Address: Spring Hall Mount Binn Lane Huddersfield HD7 6NW

Application number: 2022/92922	
What is the application for?:	Engineering and other operations to form new vehicular entrance from Binns Lane
Address of the site or building:	Spring Hall Farm, Binn Lane, Marsden, Huddersfield, HD7 6NW
Postcode:	HD7 6NW

Title
Proposed site plan and cross sections.

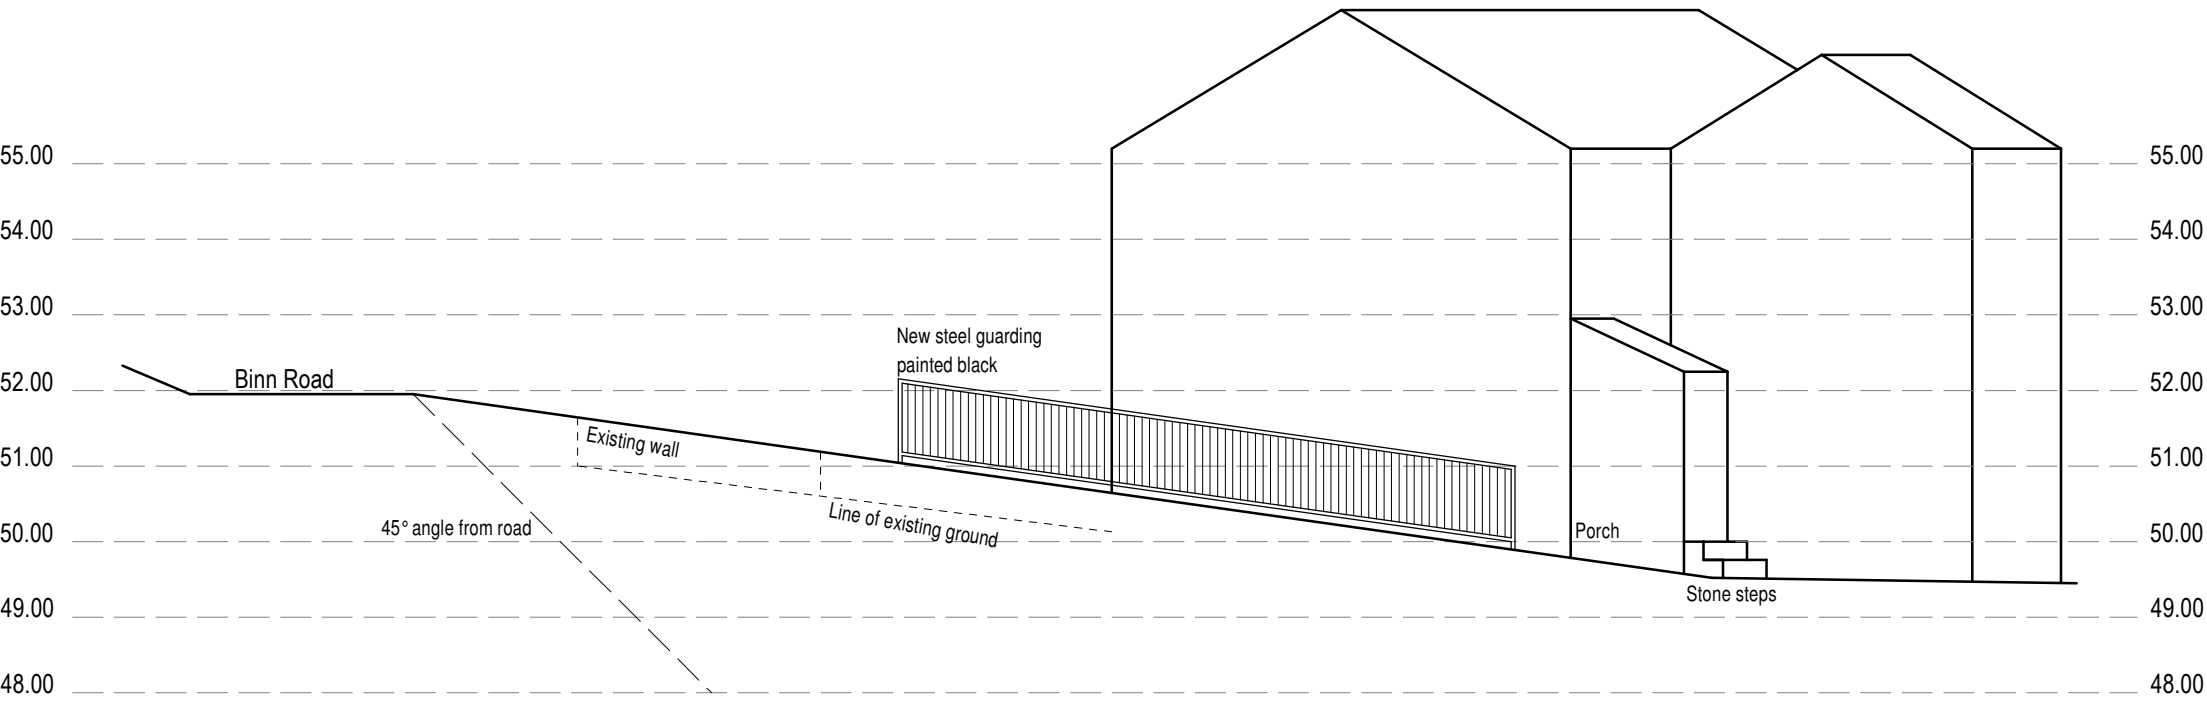
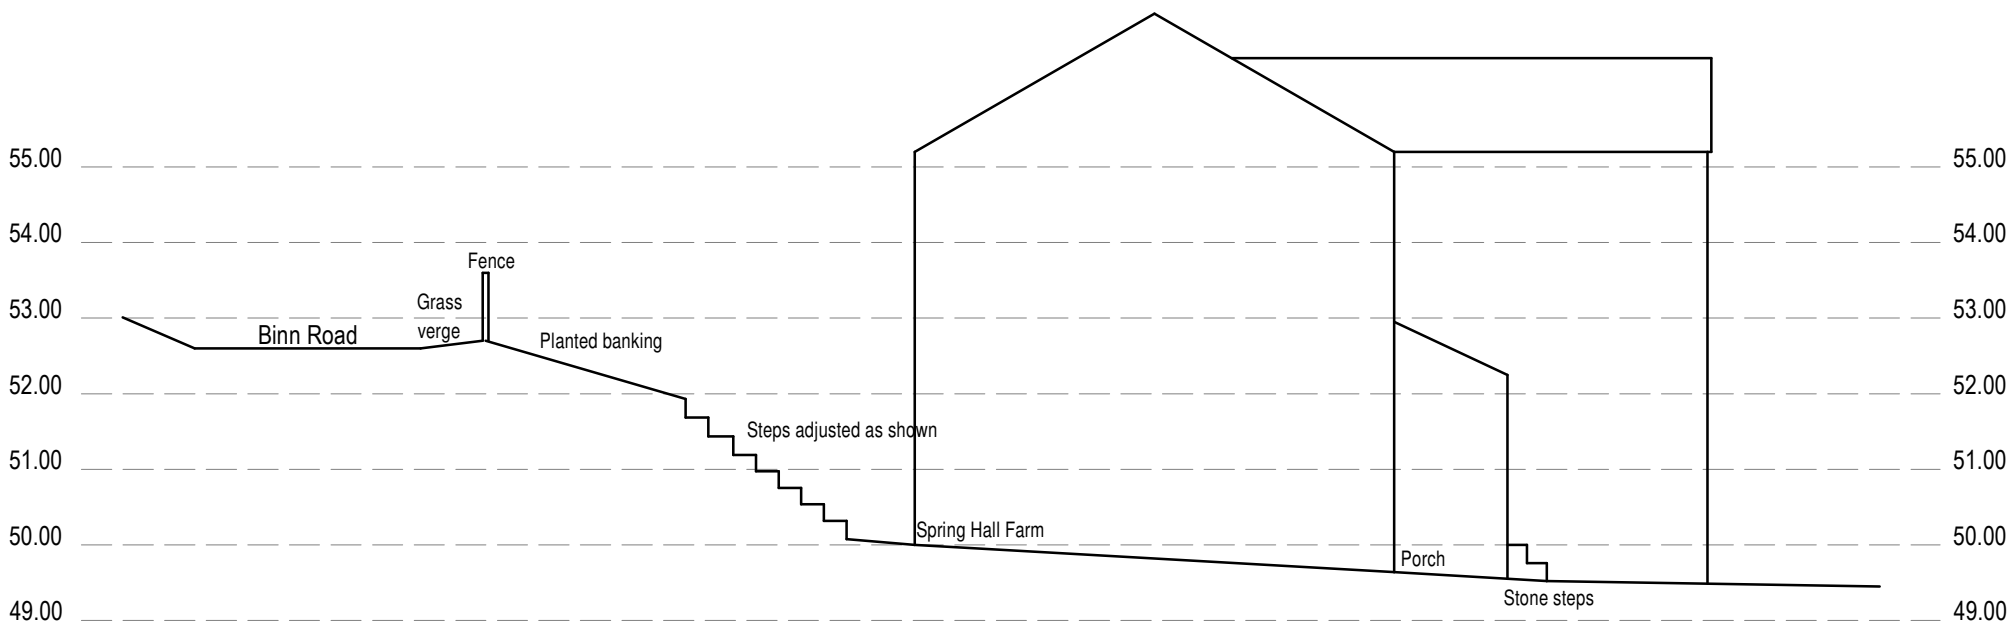
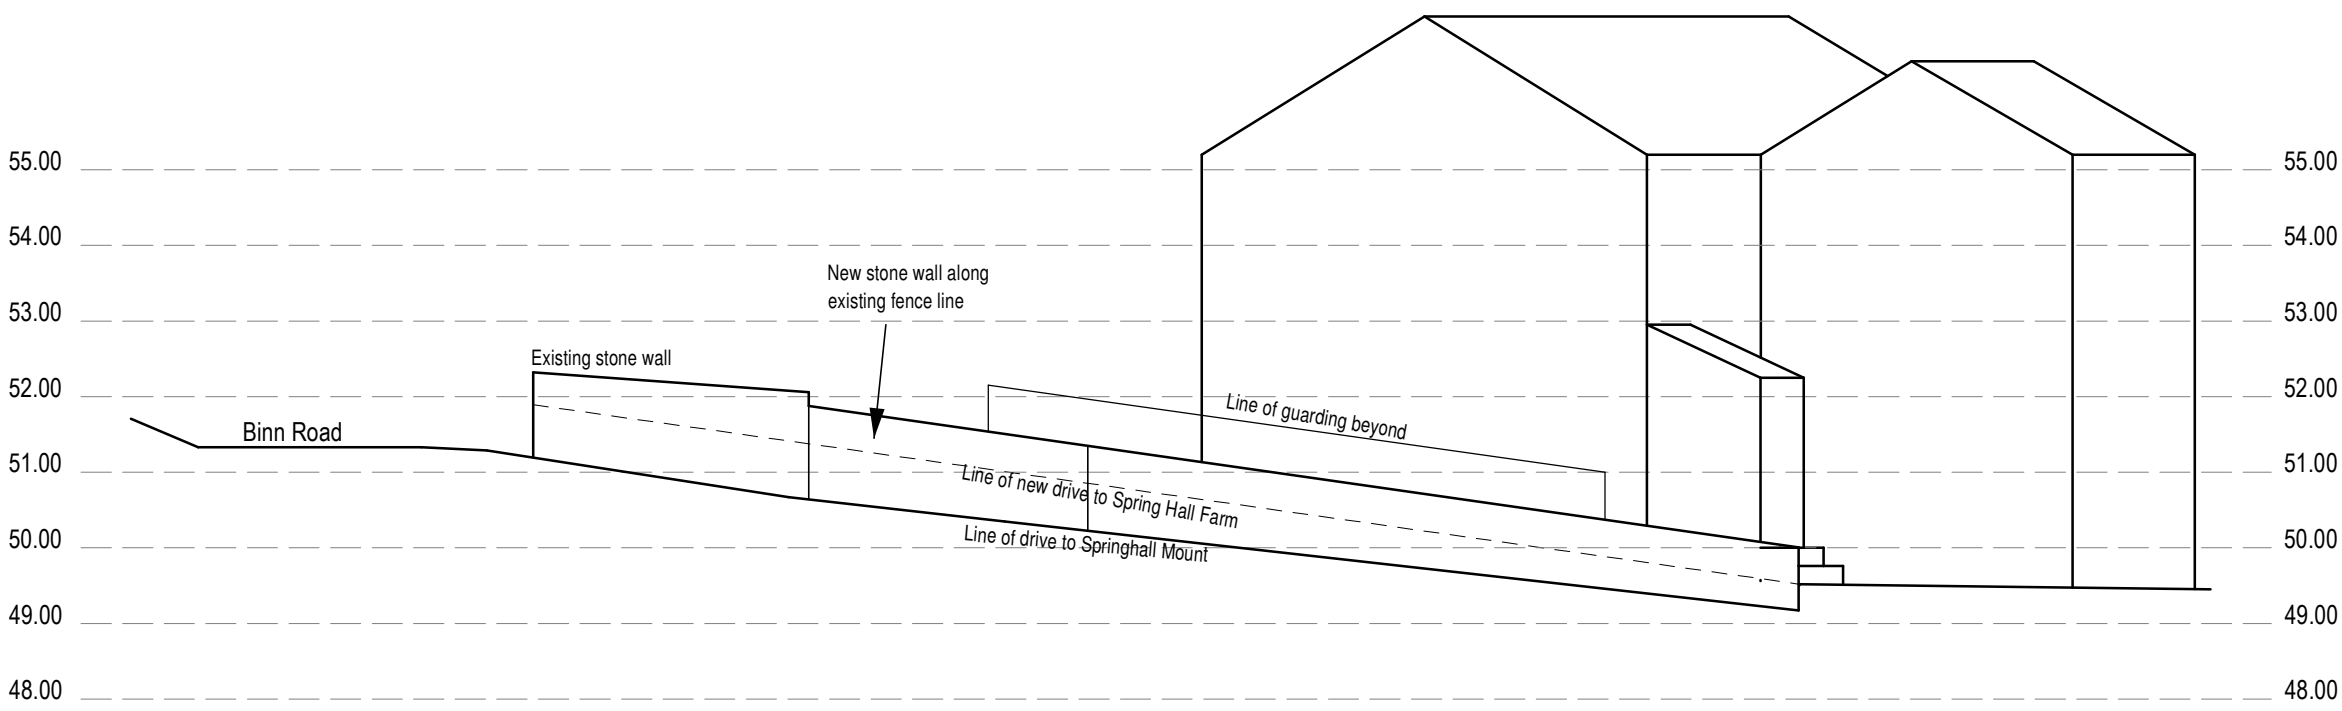
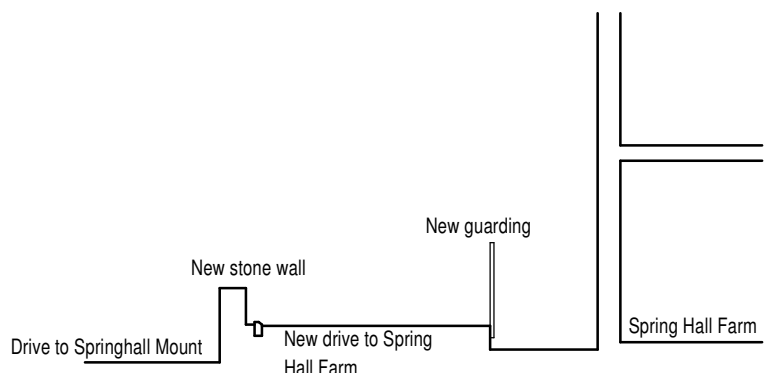
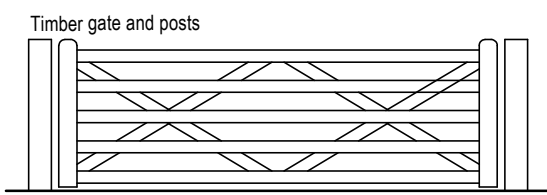
The new wall will form a boundary with our home, a grade 2 listed property. There is no information as to the type of construction or materials that the applicant plans to use. There is also insufficient detail as to the exact location of the wall and the proposed height. We have not been notified that the applicant will require access to complete any of the proposed works so some clarification would be beneficial.

We trust that the Planning Authority will place sufficient scrutiny on the construction of the wall to ensure that it is of a type that will not detract from the setting and natural surroundings or interfere with the aspect of the adjoining grade 2 listed property.

We note the addition of a soakaway however this would appear to only be useful for water entering into Spring Hall Farm. It is not clear how water will be prevented from causing flooding to the lower part of our driveway and outbuilding.

The current plans show the new driveway encroaching onto Binn Lane without any barrier to prevent surface road water entering our property.

The soft verge that forms part of the highway presently helps to prevent flooding with excess water being soaked away or channelled into roadside drains.
